Ribble Valley Borough Council
Housing & Development Control

Application no: **3/2024/0400**

Address: **Whalley Railway Viaduct Broad Lane Whalley BB7 9RS**

Proposal: **Approval of details reserved by condition 5 (traffic management plan) of listed building consent 3/2024/0083.**

SITE TRAFFIC

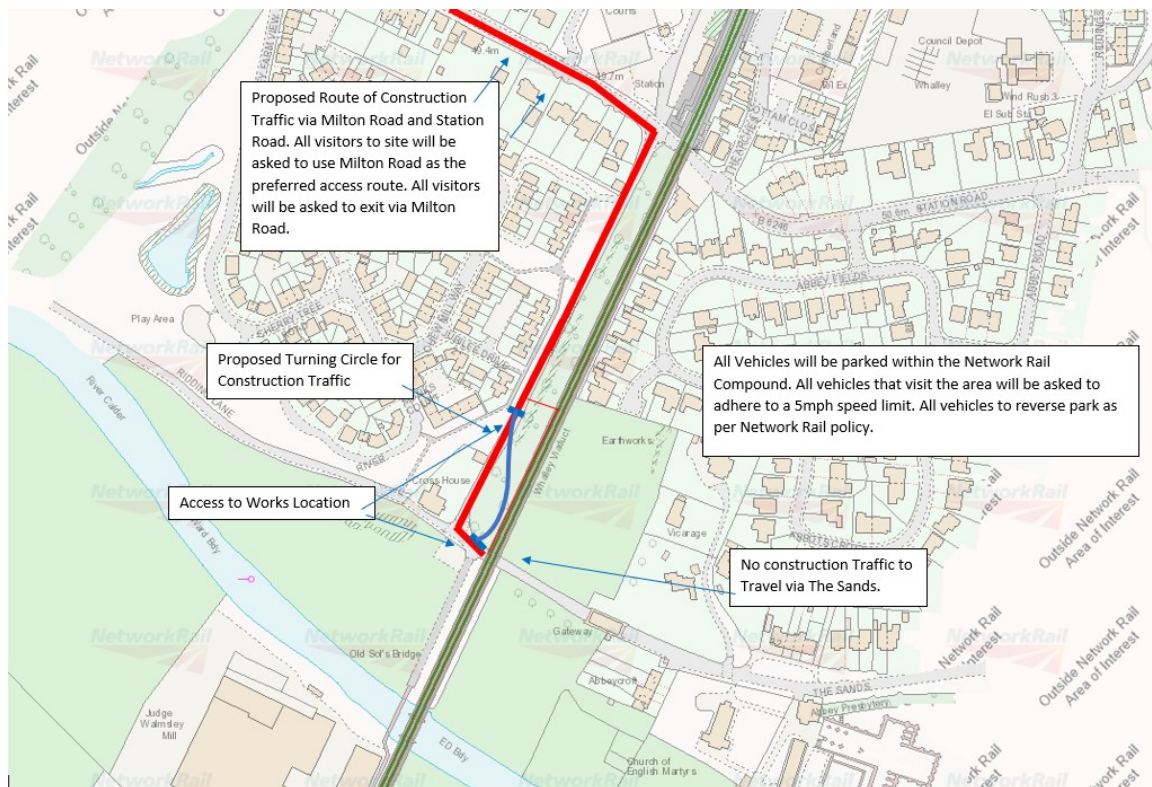
The LHA have reviewed the provided Construction Management Plan and as presented object to the discharge of condition. This is because the LHA require further details regarding the proposed access arrangements to the compound area. The LHA require a detailed site access drawing to be provided along with a scaled compound plan showing where operatives will park, where materials will be stored and where vehicles will access the area.

The LHA are concerned that should large, high sided vehicle use Broad Lane during the construction phase they may conflict with the trees overhanging the highway. To protect the tree and the vehicle, the trees will need to be cut back should high sided vehicle visit the site. The LHA also require a traffic management plan to be provided showing construction signs warning road users of the construction site. This is paramount given that Broad Lane has no access to a segregated footway.
